CITY OF PORTLAND, MAINE

Re: BOWL PORTLAND
Address: 58 ALDER STREET CBL: 034-H-002-001
Project ID: 09-79900009
Applicant: JUSTIN ALFOND AND CHARLES MITCHELL

November 10, 2009

L.2

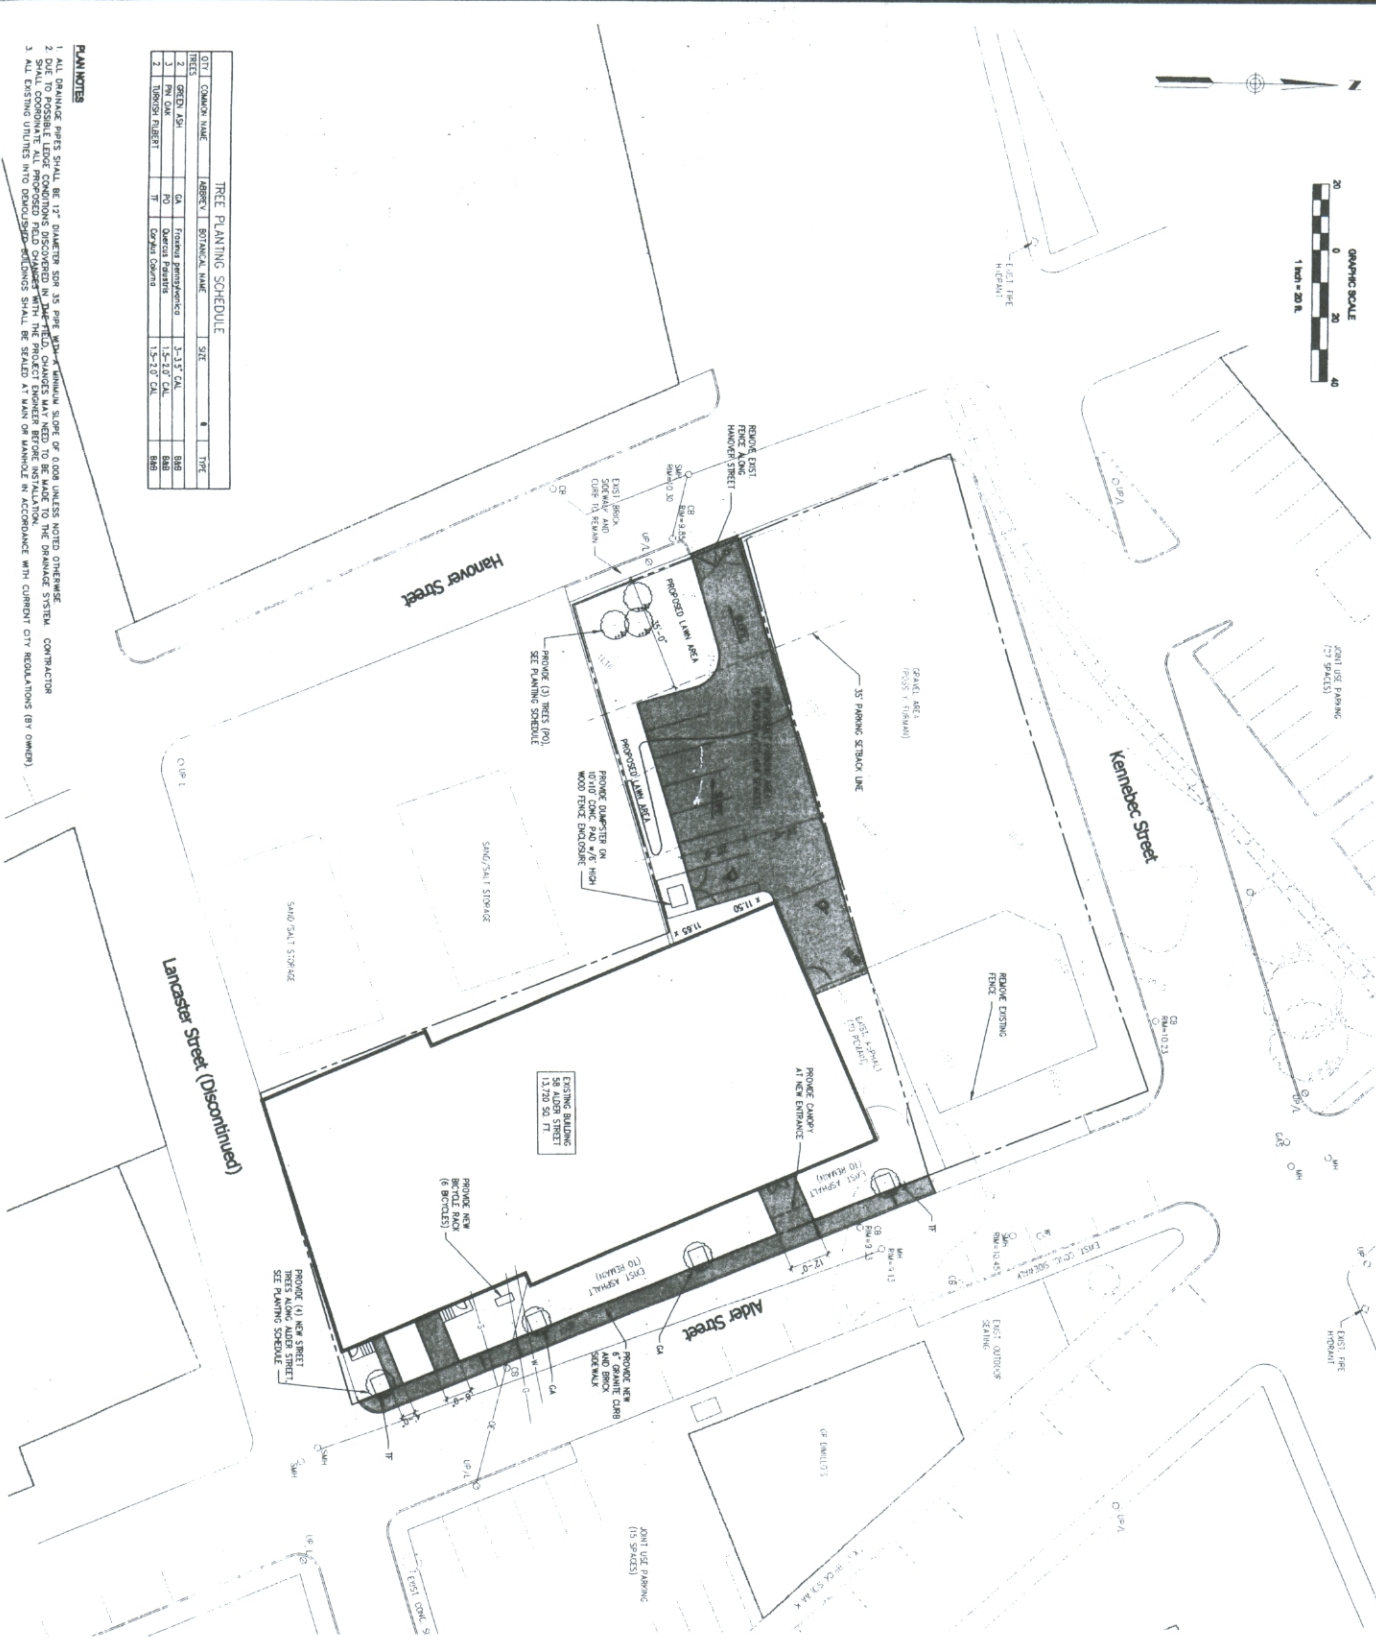
a) **Alder Street** - Add one additional 'street-tree' in the large center island between the two shown. Also a question on the L-2 plan is the note 'existing asphalt to remain' - would there be an option to soften this space with landscape plants or turf for the large paved area behind the sidewalk & at the corner? This space could benefit from a reduction in impervious surface.

2. It appears that two curb cuts are proposed along Alder Street but the plans are not clear. Unless the applicant can explain a need for drive cuts in this area, this section shall be all granite curbing with a seven inch reveal.
I believe it is the applicant's intent to show raised granite curbing along the entire property on Alder St. Sheet L.2 shows a double line for curbing but for only a portion of the property.
